# CITY OF ALBUQUERQUE

RE: **Lot 15 Block 1 Unit 22 SAD 228 Volcano Cliffs Subd.  
8009 Agua Fria Ct. NW  
Grading and Drainage Plan  
Engineers Stamp Date 10/29/2020 (D10D003N15)  
Pad Certification Date: 3/11/2021**

Based upon the information provided in your submittal received 3/31/2021, this plan cannot be approved for Building Permit until the following comments are addressed..

SHEET TITLE: GRADING AND DRAINAGE PLAN

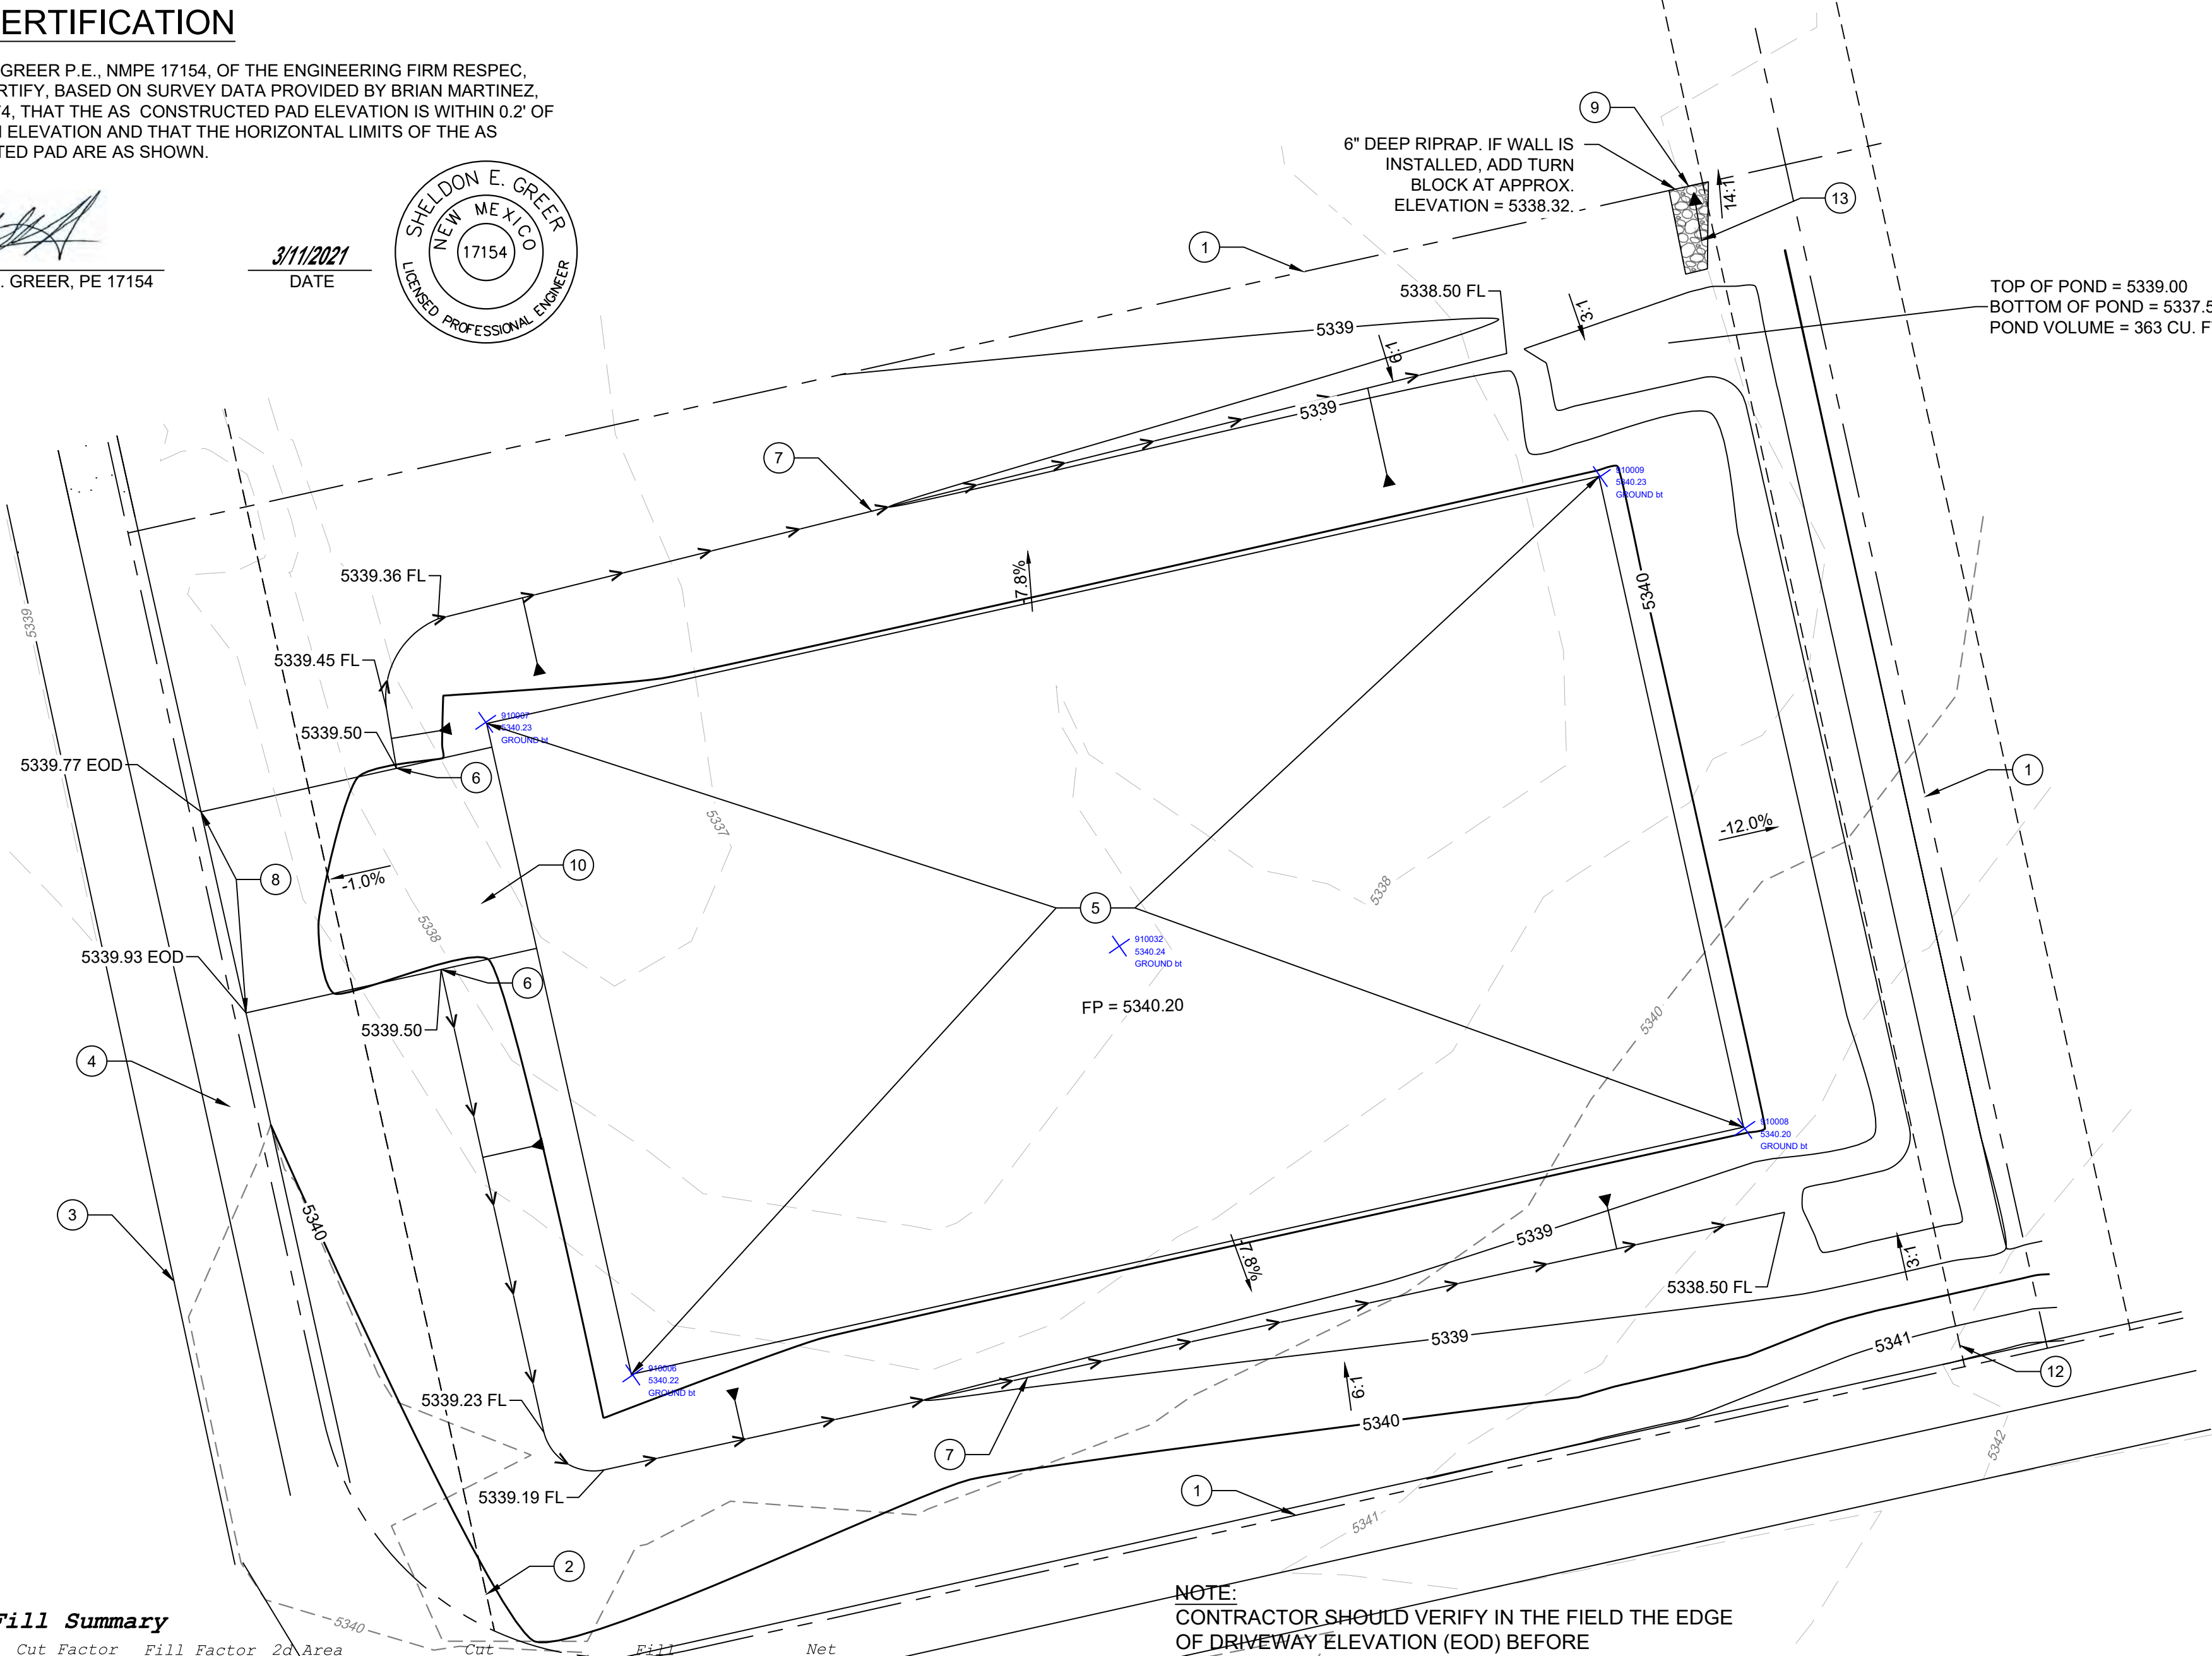
- Remove all dirt from the street. Dirt is not allowed to use as a ramp for going over the curb, only lumber or crusher fines are acceptable.
- Remove the dirt in the channel, it is blocking the flow from Alto Rey Ct. to Agua Fria Ct.

Reiterate to the Owner/Contractor that a separate permit for a garden/retaining wall must be obtained with the approved G&D plan and Pad Certification. **Also, if a swimming pool is to be placed the grading and drainage plan will change and will need to be resubmitted.**
